RESPONSE TO SUBMISSIONS PART 1 – SSD11869481 - UPGRADES TO NORTH SYDNEY PUBLIC SCHOOL

Response to Submissions Matrix

DRAWING NUMBER
SD-1108

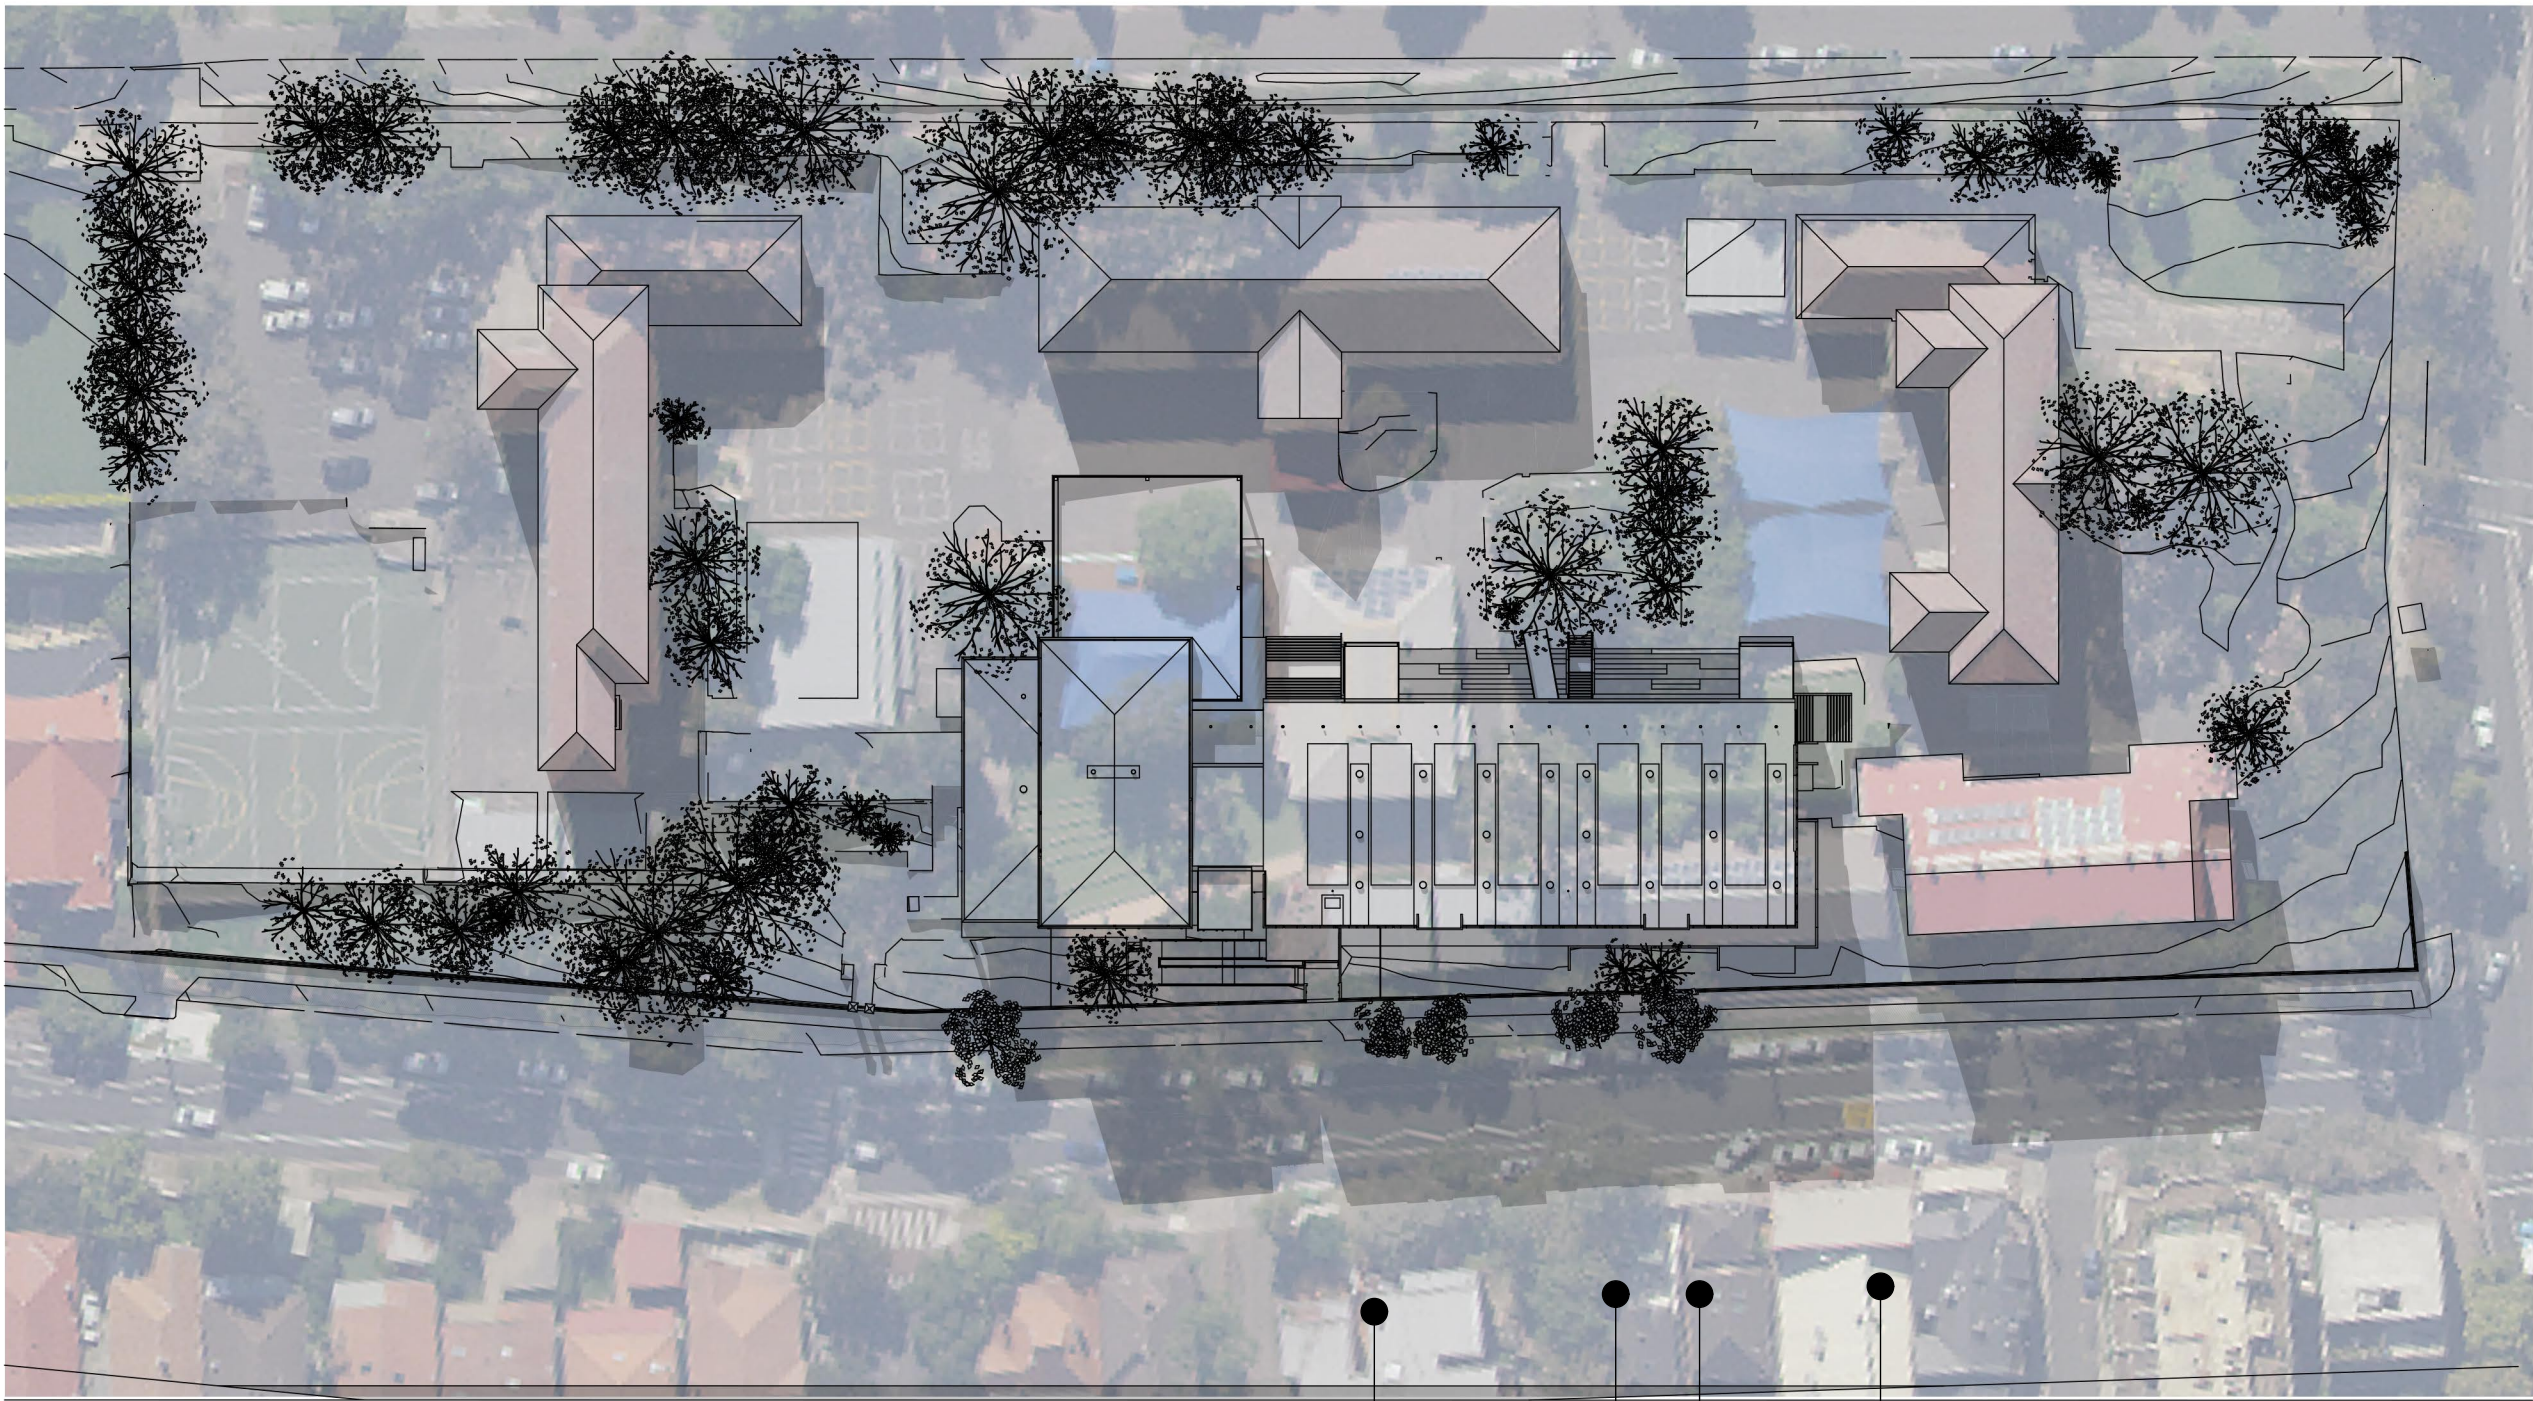
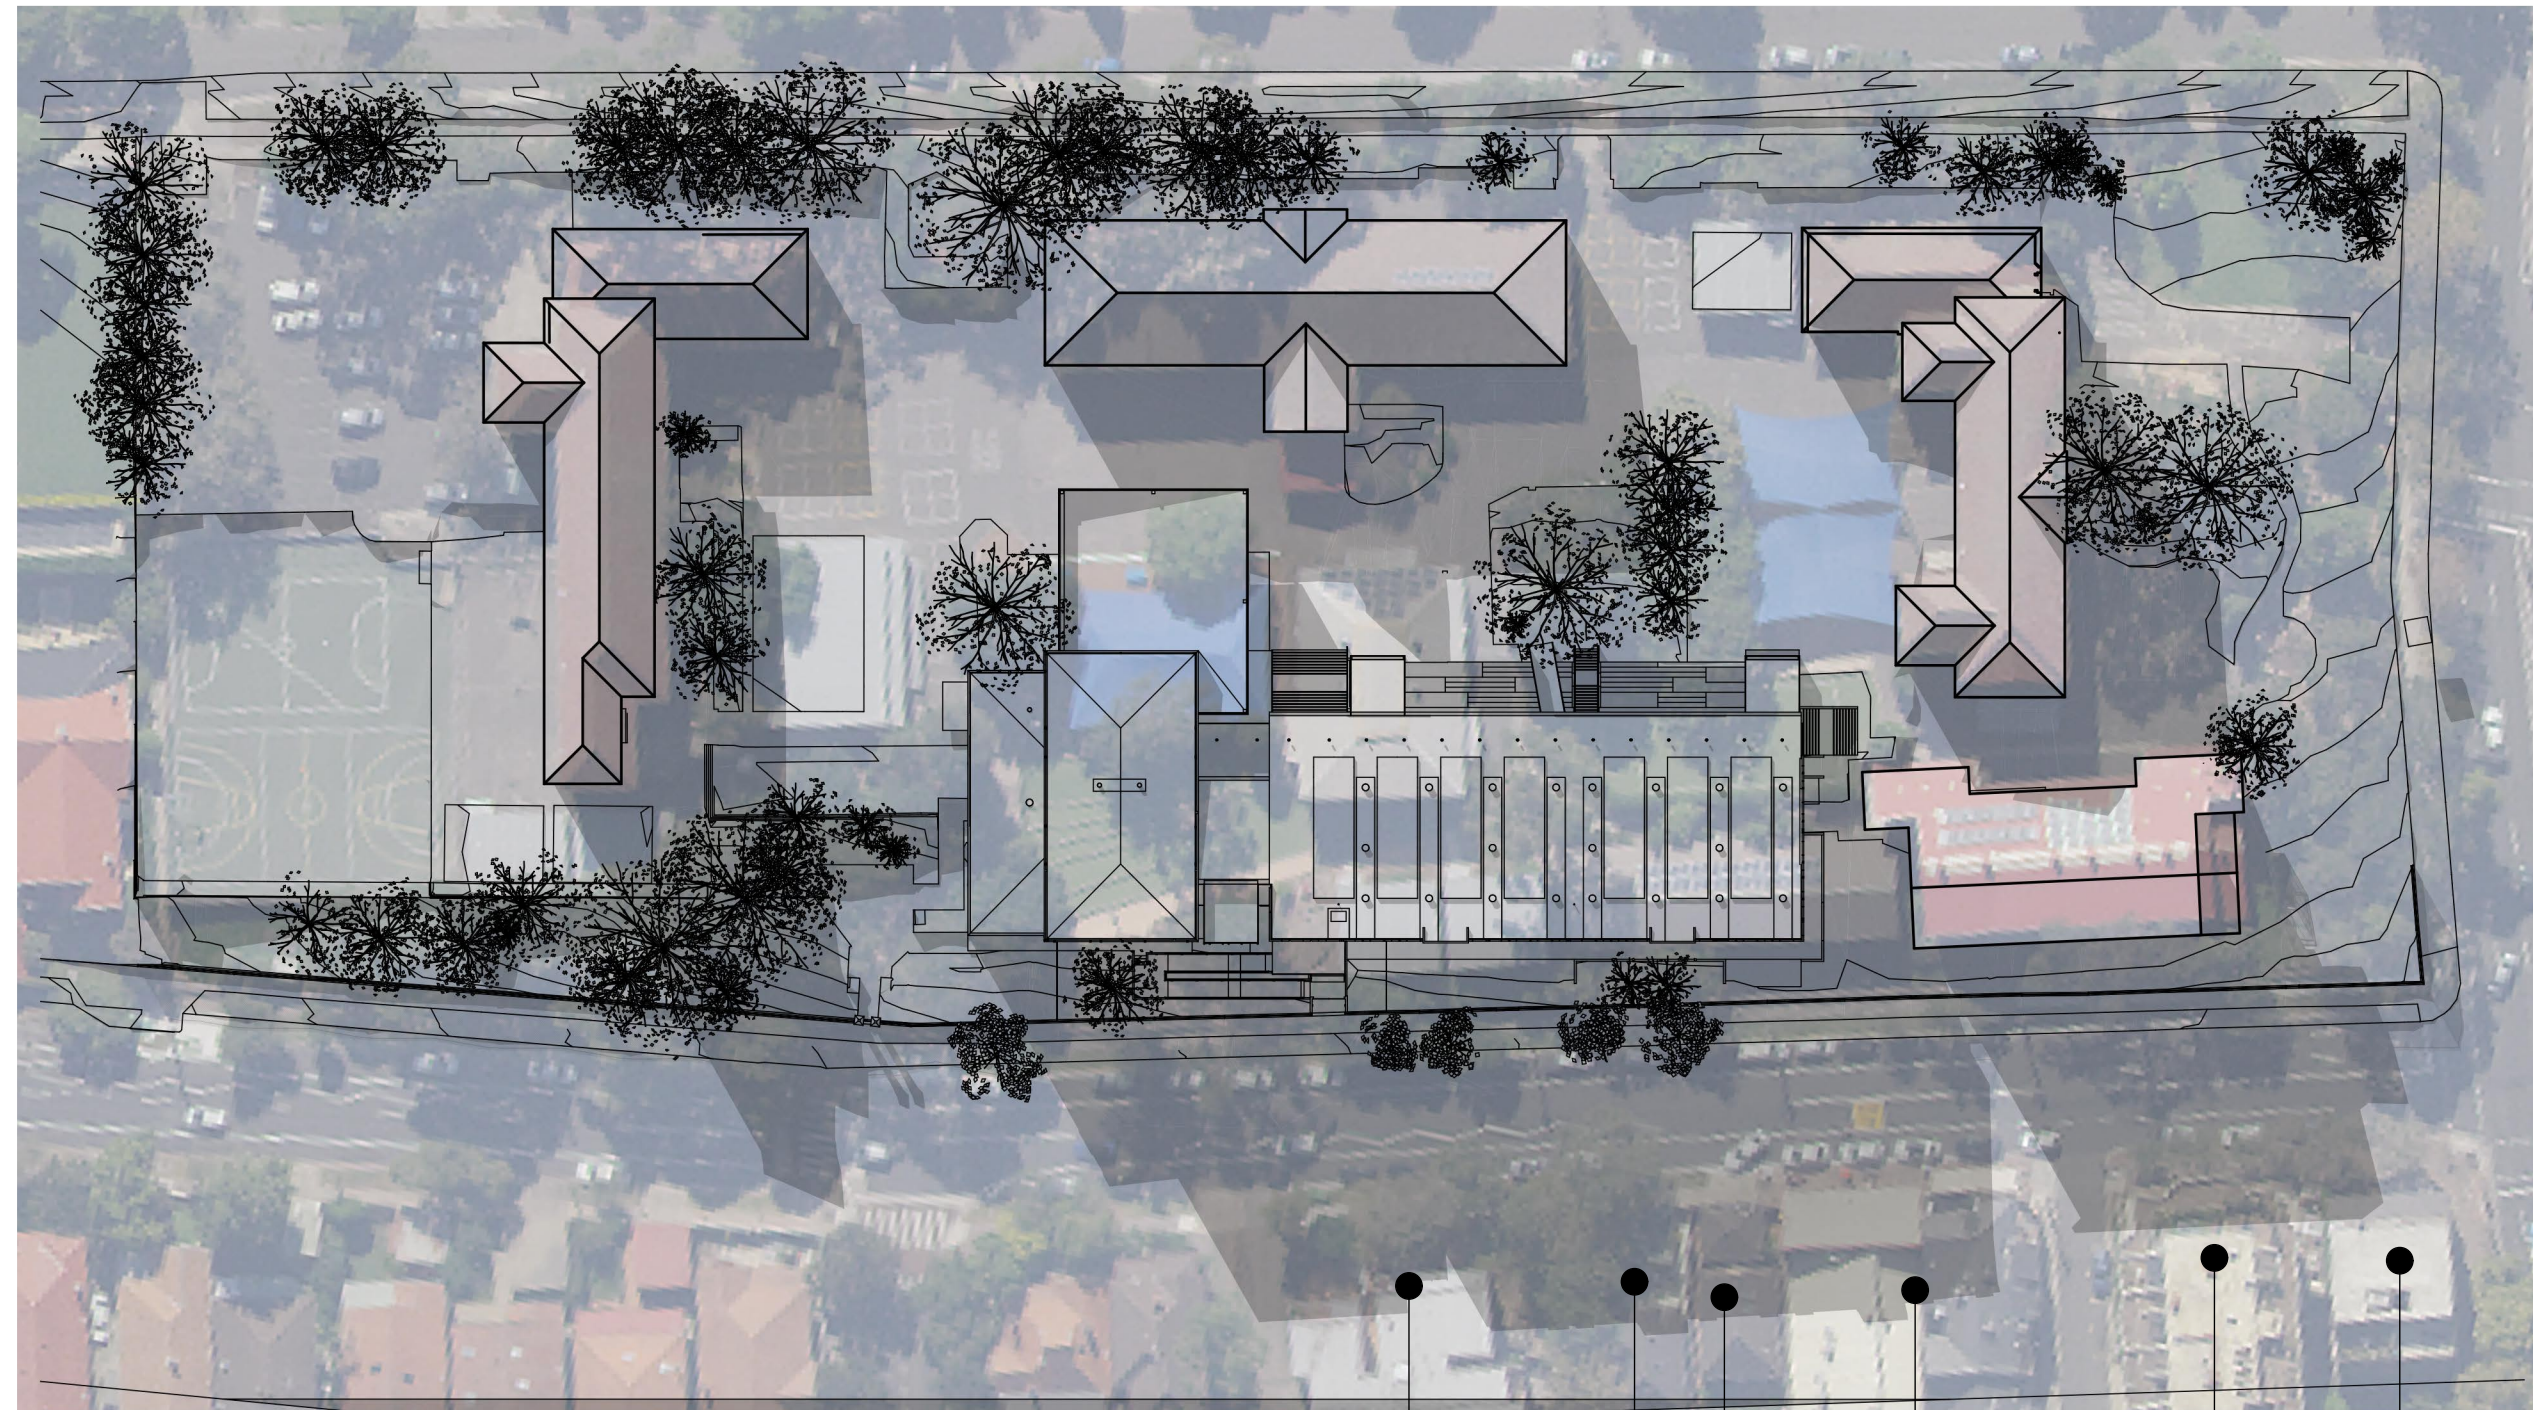
AGENCY	SUMMARY OF MATTERS RAISED	PROPONENT'S RESPONSE
	<p>construction worker parking does not detract significantly from existing on-street parking supply.</p>	
	<p>Built Form and Urban Design</p>	<p>A detailed response to DPIE and GANSW's built form and urban design feedback will be provided in part two of the RtS, following the SDRP meeting on 10 November 2021.</p>
	<p>Address the Government Architect NSW comments on the EIS dated 6 October 2021.</p>	
	<p>Shadowing</p> <p>Sections 7.3.2 and 7.1.2 of the EIS state that shadows generated by the proposal would not impact surrounding development and that shadows would fall onto Bay Road and the footpath at 3pm in mid-winter. The shadow diagrams lodged with the EIS show that at 3pm shadows are cast across Bay Road and onto properties opposite the site on Bay Road. To allow for proper assessment of shadow impacts, hourly shadow diagrams are required between 12pm and 3pm in mid-winter, and elevation shadow diagrams are required to demonstrate from what time and where shadows will fall on north facing elevations of development opposite the site on Bay Road.</p>	<p>Following discussion with DPIE on 22 October 2021, it was agreed that hourly plan shadow diagrams would be sufficient in demonstrating/assessing the shadow impact of the proposal, as opposed to requiring submission of elevational diagrams. To this end, Fulton Trotter has prepared hourly interval shadow diagrams for the mid-winter period and they can be found at Appendix 5. The shadow analysis clearly demonstrates the shadow cast from the proposal starts to encroach within the boundaries of a series of properties on the southern side of Bay Road at 2pm. These properties comprise a mix of single residential dwellings, to three (3) storey apartment buildings and a few mixed-use developments closer to the Pacific Highway (with retail at the ground floor and residential apartments above). However, as can be seen in the extracts below, which provide a snapshot of the shadow impact at 2pm and 3pm, there is very little impact at 2pm. The impact is more evident at 3pm.</p>

- At 2pm, there is overshadowing to Bay Road, the road reserve and what appears to be a very minor part of the front boundary of 12-14, 10, 10A (which is a battle-axe lot), 8B (which is also a battle-axe lot), 10 and 8A Bay Road. No dwellings or habitable areas are affected. A very minor shadow is cast to a very small part of the northern façade of the garages to 10 and 8A/8B Bay Road.

AGENCY	SUMMARY OF MATTERS RAISED	PROPONENT'S RESPONSE
		<ul style="list-style-type: none"> At 3pm, the proposed building will cast a shadow to the properties located at 4B Bay Road through to 12-14 Bay Road. The impact in this regard is considered to be reasonable, given at all periods prior to this time in mid-winter, these properties (and any internal living areas off the front/northern elevation) continue to maintain and benefit from generous direct sunlight from 9am to 2pm. <p>The dwelling houses on the southern side of Bay Road receive more than 3 hours of solar access between 9.00am and 3.00pm mid-winter in accordance with Section 1.3.7 of the North Sydney Development Control Plan 2013. Furthermore, the units in the residential flat buildings receive greater than 2 hours solar access between 9.00am and 3.00pm mid-winter in accordance with Part 4A of the Apartment Design Guide.</p> <p>Having regard to the above and detailed hourly shadow diagrams at Appendix 5, we consider that the level of impact, which is restricted to 3pm in mid-winter, is reasonable and will not result in any unreasonable loss of amenity for the aforementioned properties on the southern side of Bay Road.</p>
